Application No: AW/66/22/HH
Site Address: 36 Kingsway Aldwick PO21 4DH
Description of works: Addition of a first floor with pitched roof to the existing flat roof garage. This application affects the character & appearance of the Craigweil House Conservation Area.

Thank you for your internet representation made on 10th April 2022 which has been recorded as an objection with the comments as follows:

Proposed West Elevation

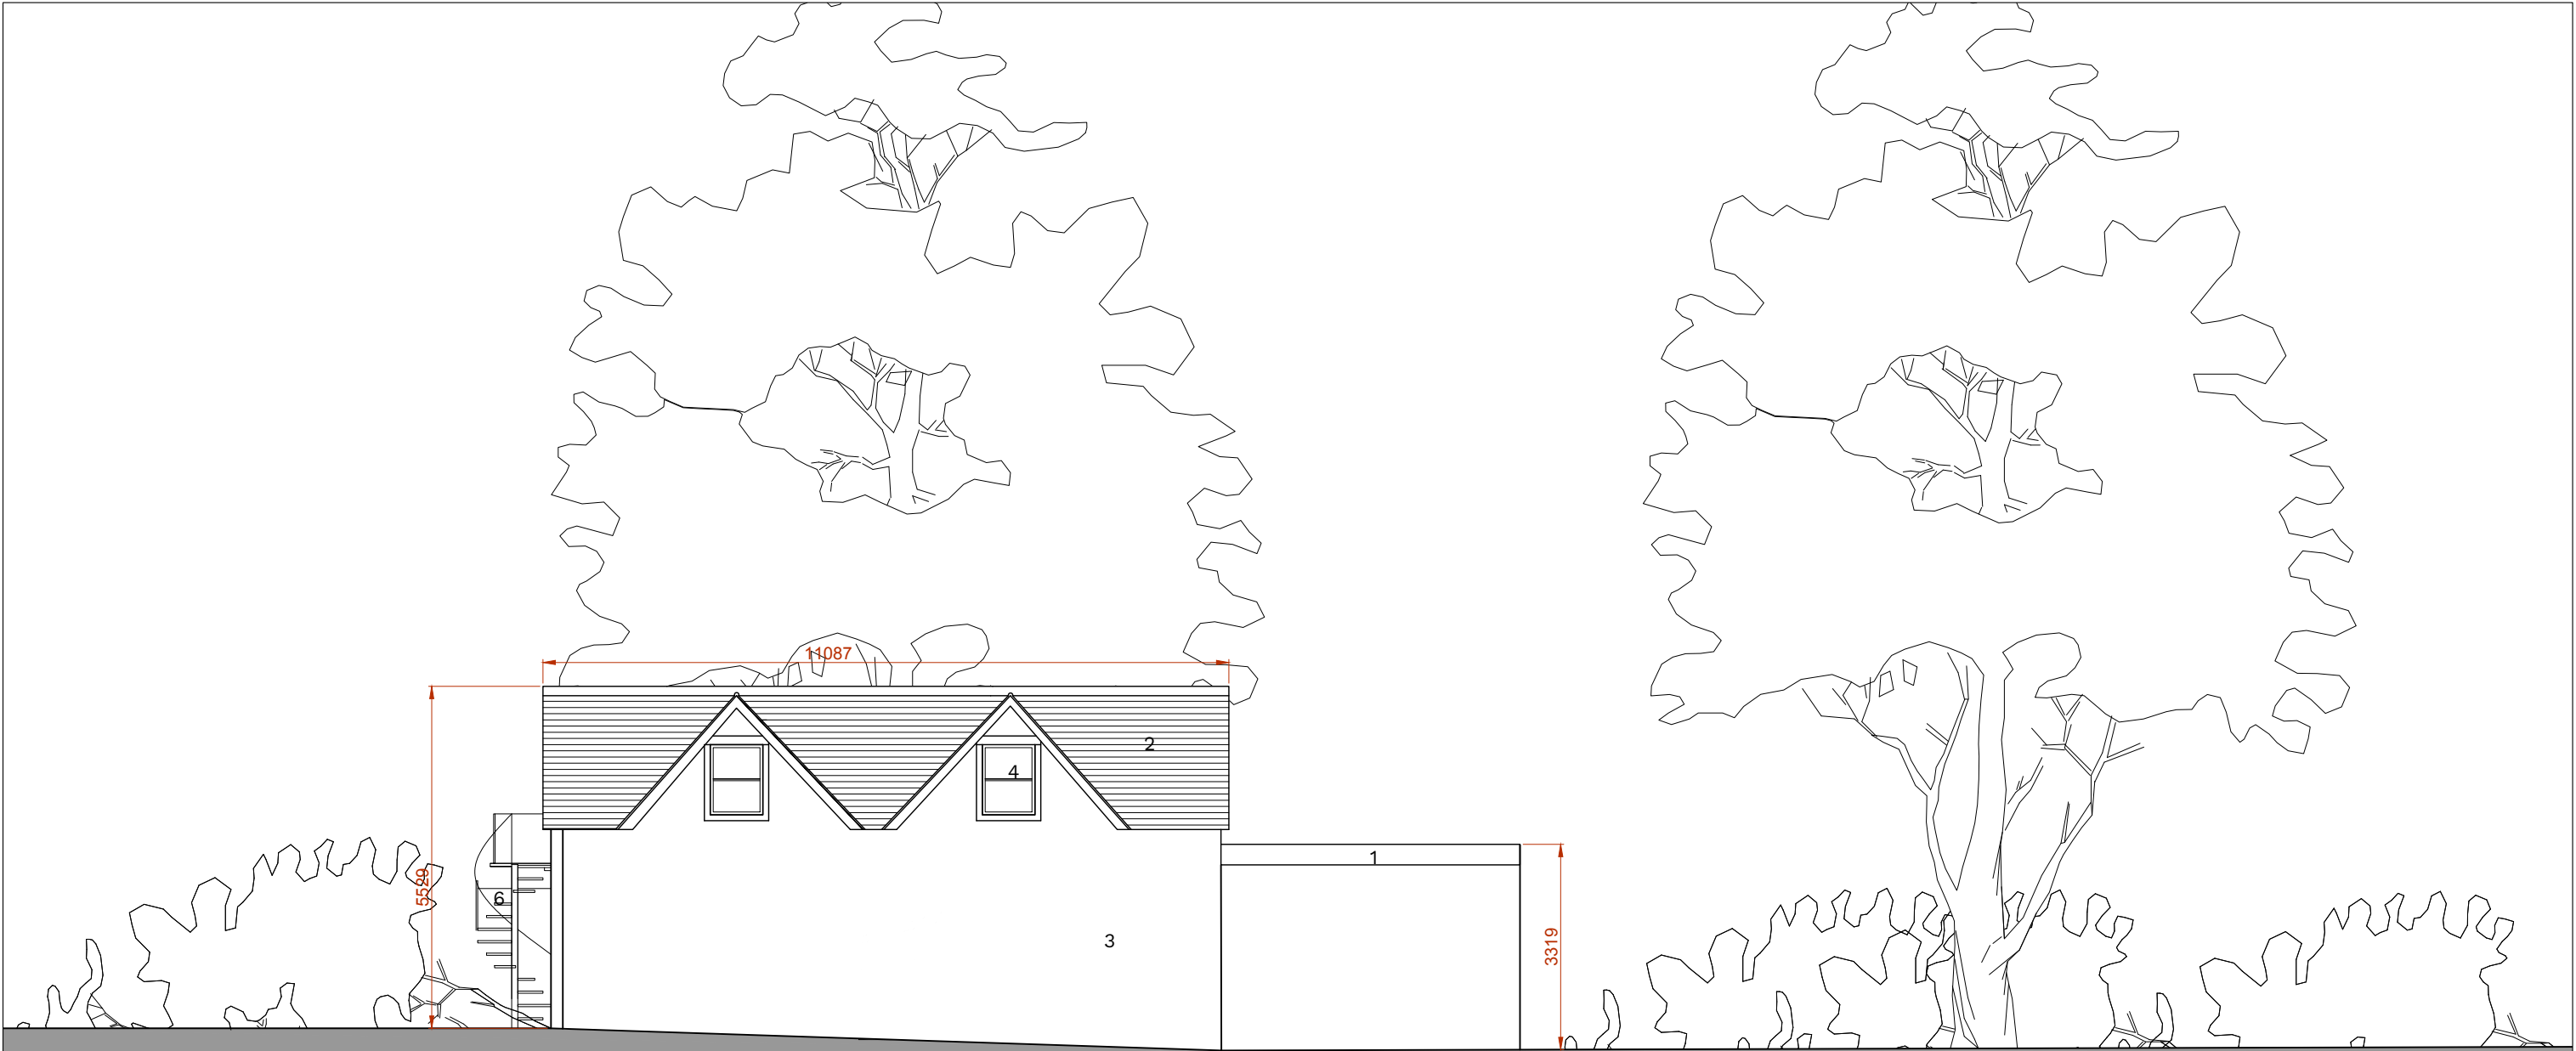
3. The proposed west elevation windows will also overlook my garden resulting in further loss of privacy.

Drawing Details
Proposed First Floor Plan
PLANNING ISSUE

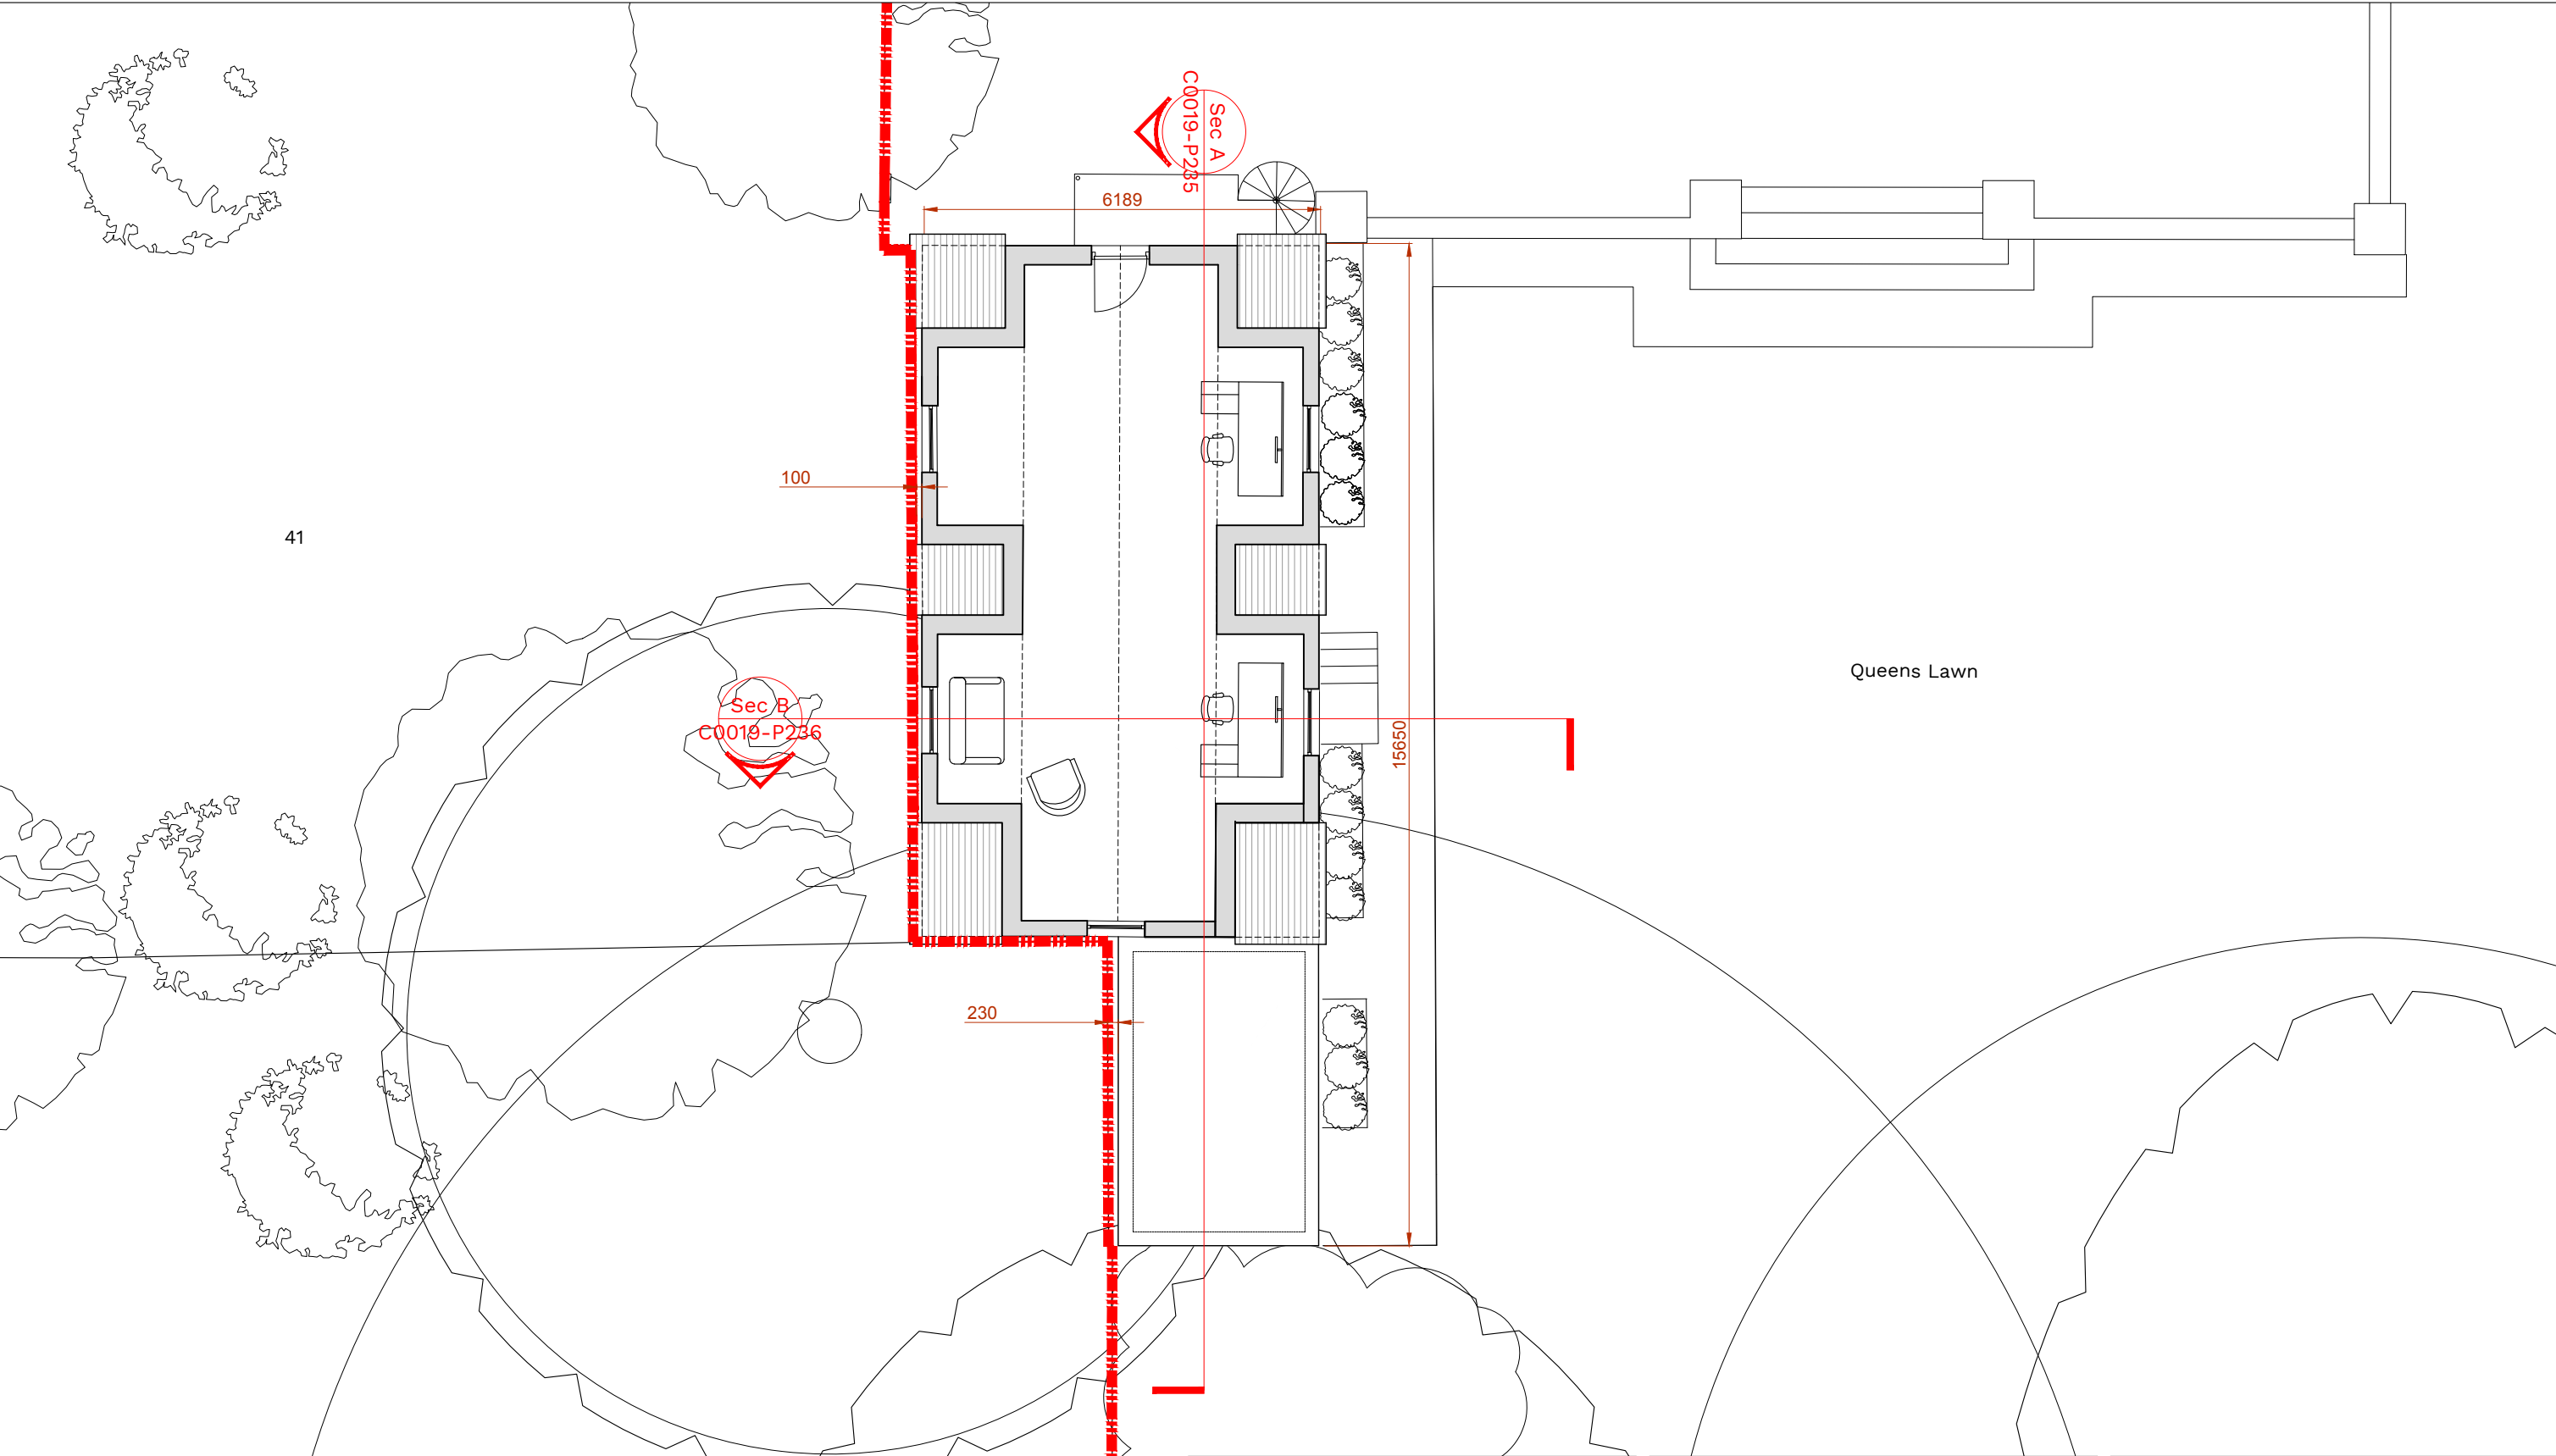
4. The application does not state the intended use of the extension but the proposed floor plan appears to indicate an office application. However, the floor area of the proposed accommodation appears disproportionate to a requirement that would otherwise be more appropriate and incidental to the employment of the dwelling house. The proposal has more the scale of a development associated with a business enterprise that is not in keeping with a private residential estate.
